Our ref: NO/2025/117121/01-L01
Your ref: 3/2025/0870
Date: 13 November 2025

**PROPOSED DEMOLITION OF FORMER MOTOR SERVICES BUILDING AND
CONSTRUCTION OF NEW OFFICE BUILDING.**

**18 ACCRINGTON ROAD (FORMER WHALLEY MOTOR SERVICES), WHALLEY,
BB7 9TD**

Environment Agency Position

Drawing Title  
**Proposed Site Plan**

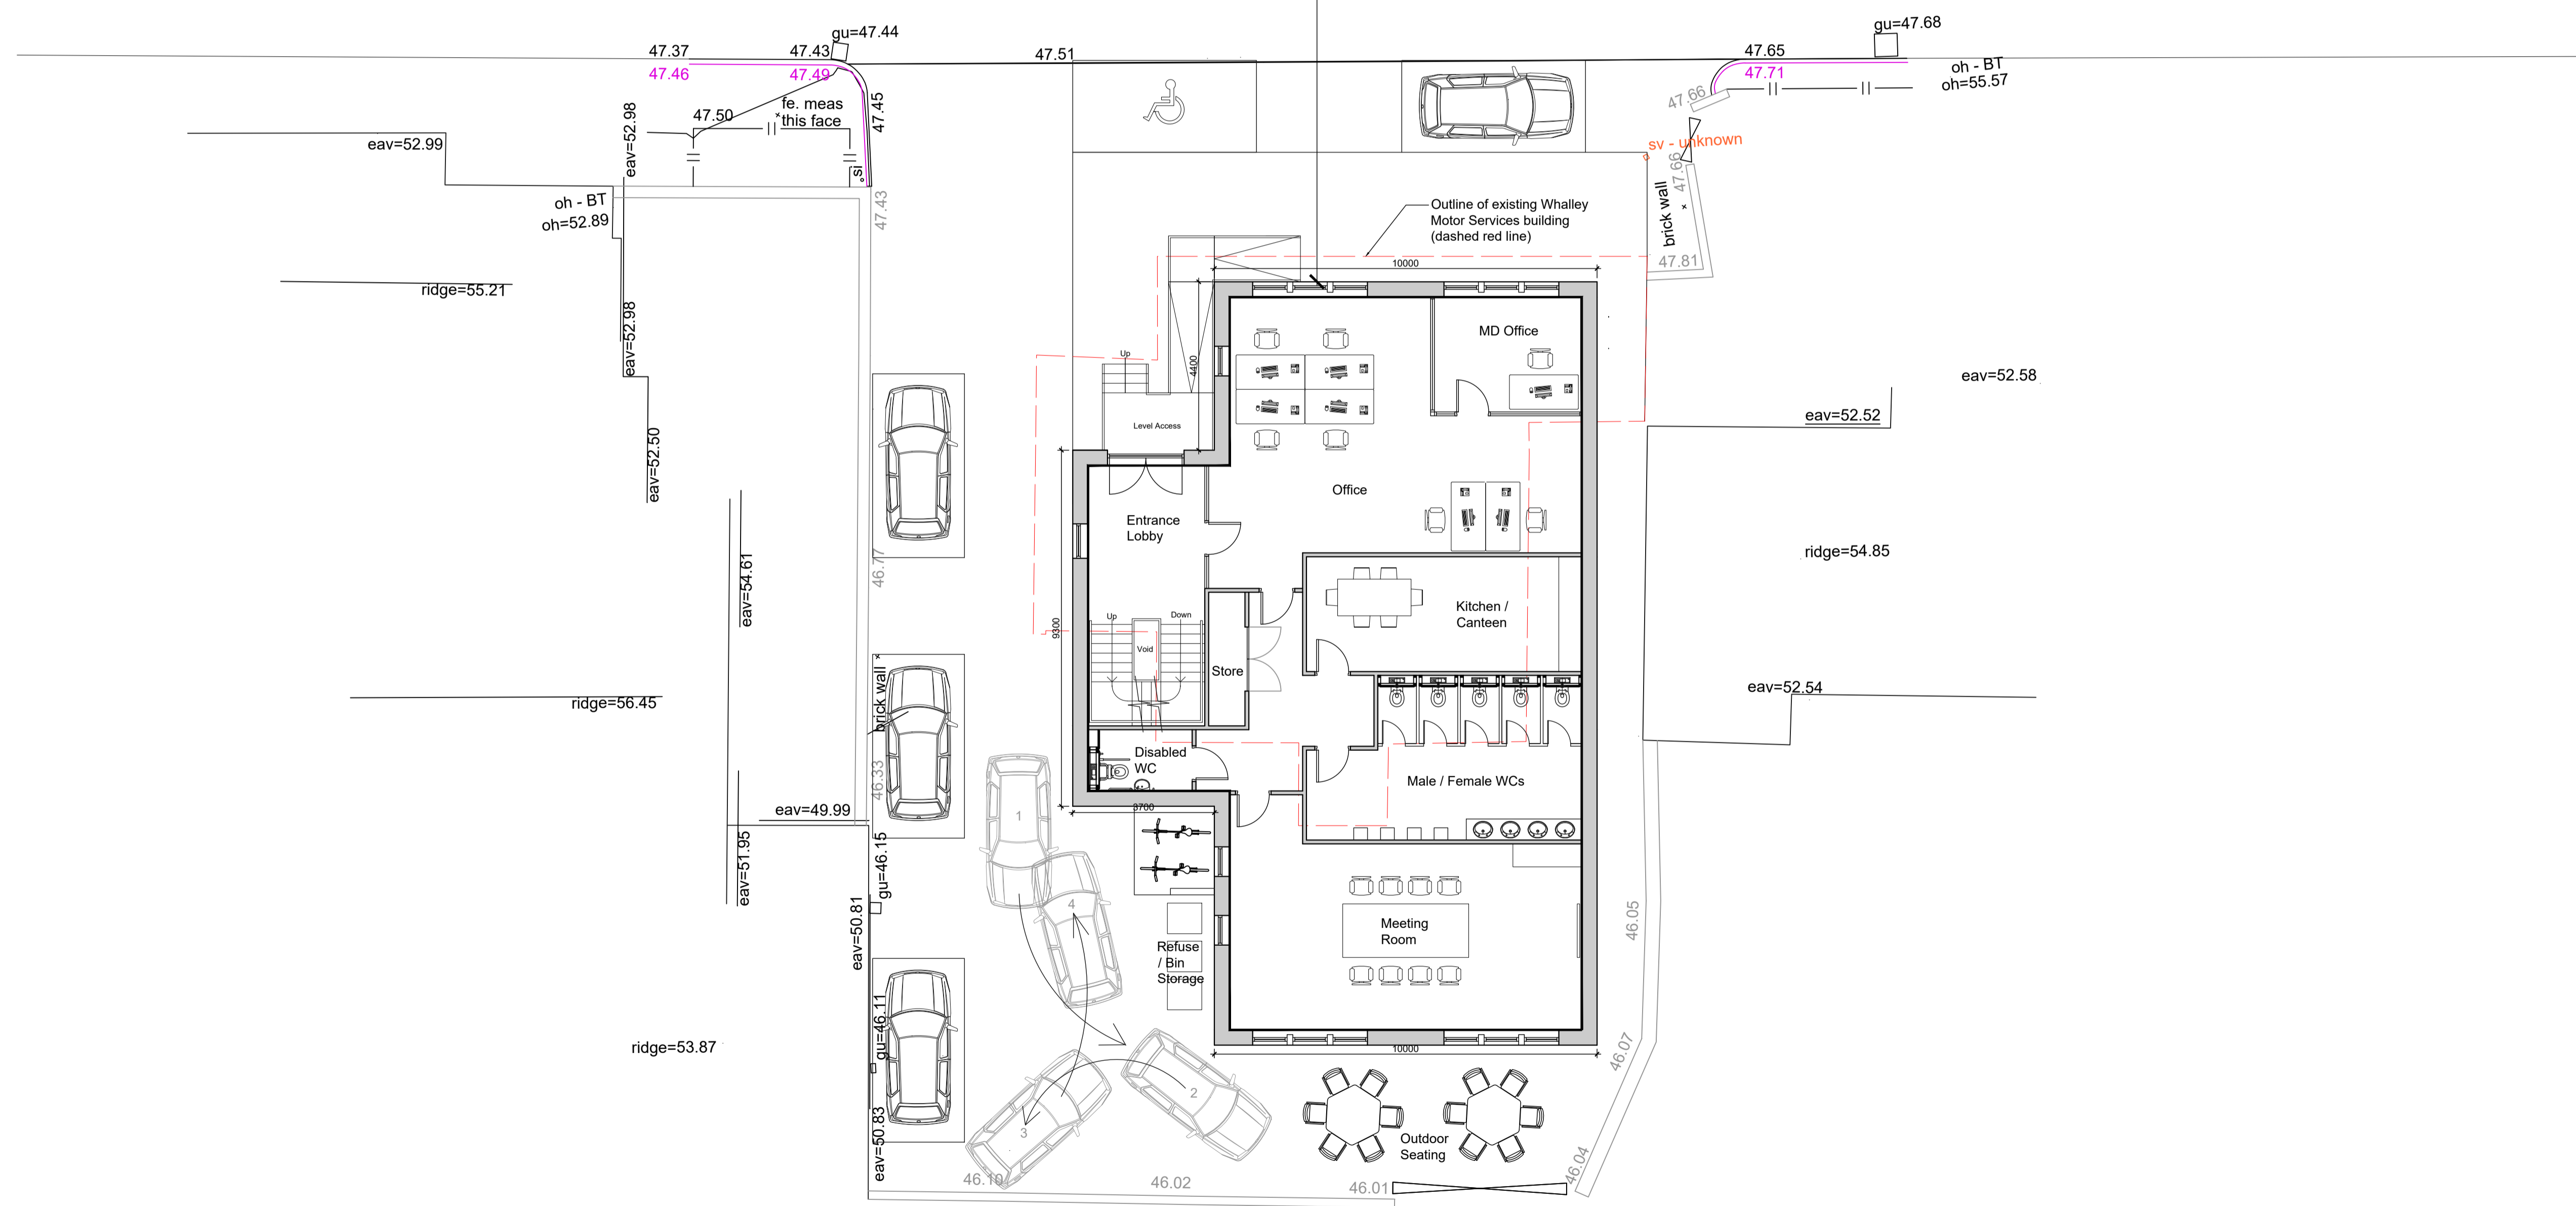
- Provide an assessment of the potential increase in flood risk elsewhere as a result of the development being located within both Flood Zones 2 and 3. Any development within the floodplain could impact the existing flooding regime whilst also, increasing the severity and frequency of flooding elsewhere.
 - The proposals include the demolition of an existing building with the construction of a new office building covering a larger footprint. The

proposed office building is shown to be in Flood Zone 2 (FZ2) and partly in Flood Zone 3 (FZ3).

- The FRA should provide a calculation of the amount of floodplain which would be lost as a result of the proposals.

- Consider the need for flood storage compensation in the floodplain (i.e. Flood Zone 3). The southern extent of the development is located within FZ3. Therefore, the FRA should demonstrate that any built development or modifications/raising of levels to external areas will not increase flood risk elsewhere (e.g. through any built development or ground level changes which may reduce flood storage / displace flood waters / affect flow routes on the floodplain).

- Where practical, compensatory flood storage works should aim to reduce overall flood risk (whether it be preferably level for level flood storage or otherwise volume for volume flood storage) from developments in Flood Zone 3. This can be most easily achieved by providing more storage than is lost due to the development, although other options may exist in other cases. This principle is also supported by the exception test. The FRA must consider compensatory flood storage for all development/ground level altering in the 1% Annual Exceedance Probability (AEP) defended/undefended flood event (plus appropriate climate change allowance) extent (i.e. future Flood Zone 3).

- The section ‘Compensation areas for construction in flood zones’ briefly outlines how this will be mitigated but additional narrative should also be added on how the storage volume calculated equates to the design flood (inclusive of climate change allowance), how the compensatory area is intended to function and subsequently drain down in the design flood event. It should also explain how the area would be maintained to fulfil this function for the required lifetime of the development.

To overcome our objection, the applicant should submit a revised FRA which addresses the points highlighted above. The revised FRA should provide consideration in relation to the impact of fluvial flood risk elsewhere. Where possible, it should reduce flood risk overall. If this cannot be achieved, we are likely to maintain our objection.
